Our Ref: CM/39/19/L

Application for Listed Building Consent for Alterations, Extension or Demolition of a Listed Building

Development Application for Listed Building consent for internal & external alterations including replacement of Upvc windows with timber windows, alteration of window to door on north elevation & additional window to west elevation, formation of new door opening to exterior, internal partition to form separate bathroom, new steps & balustrade to entrance door, roofing works & reinstatement of existing & new garden walls.

Location The Mill Cottage Climping Street Climping

Location Plan: 1:2500@A3

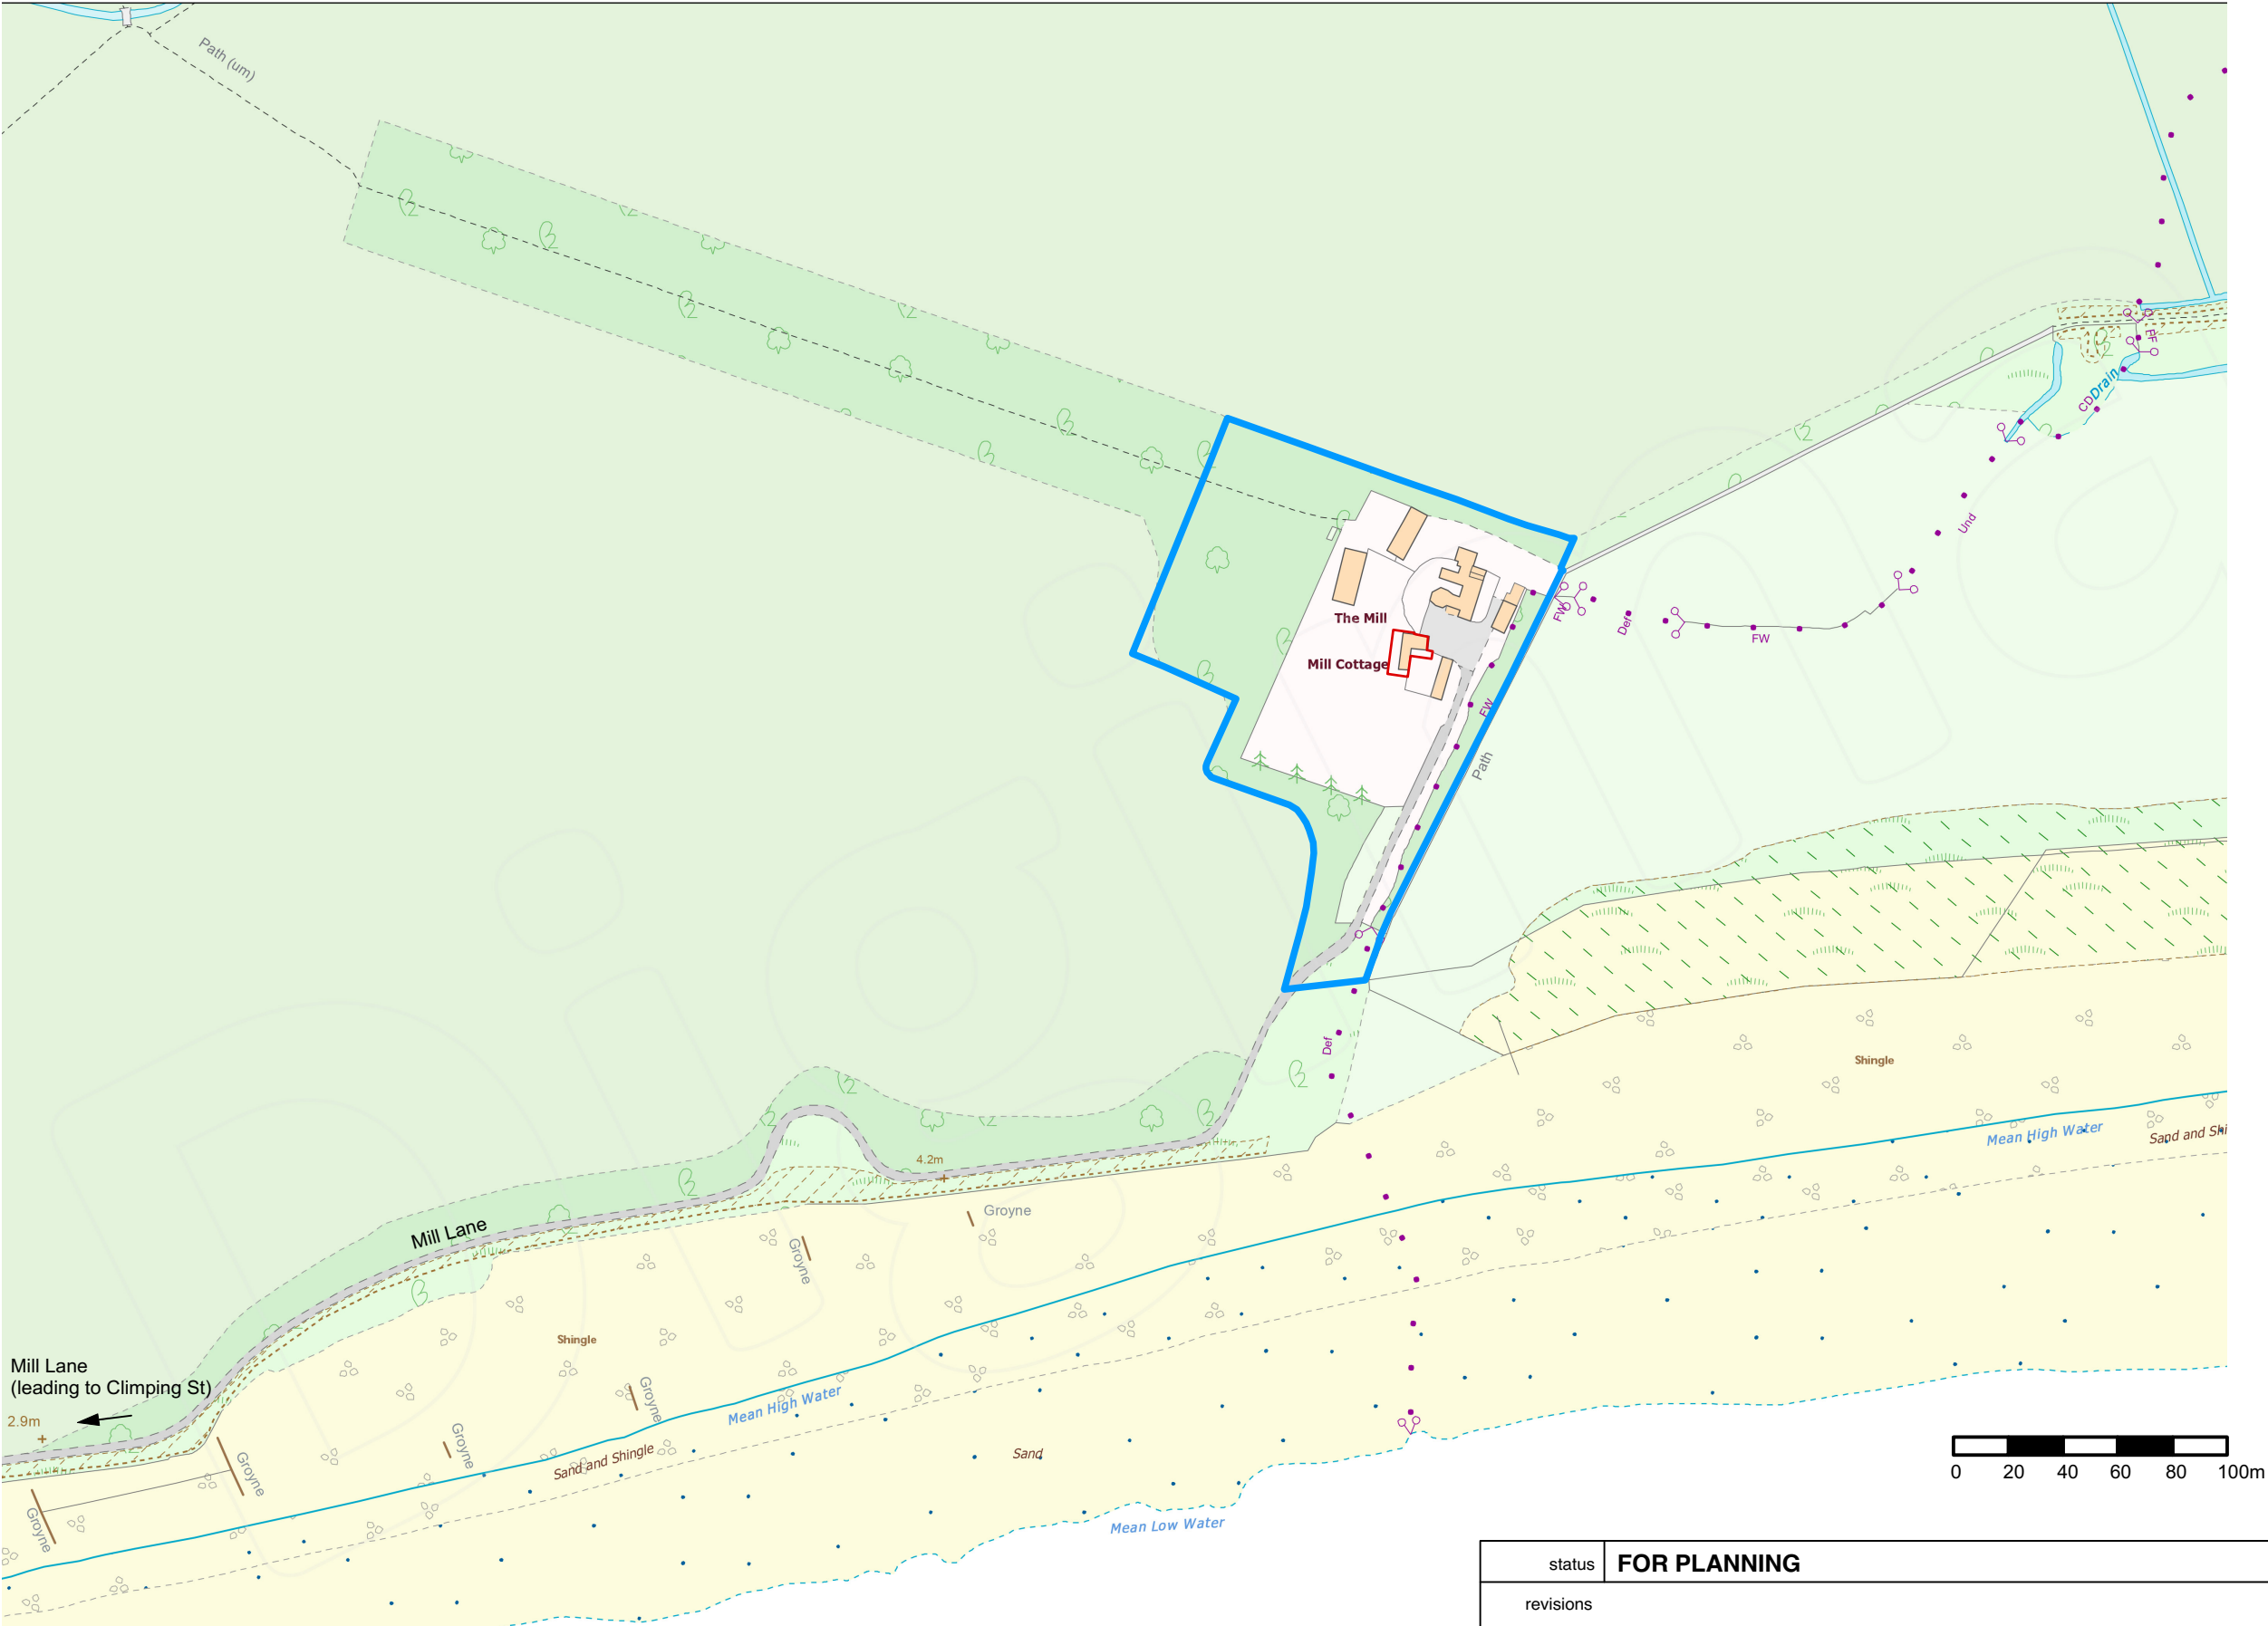
The edging on the location and block plan are incorrect. The site area needs to be edged in accordance with the previously approved application CM/6/19/HH and any other land owned edged in blue
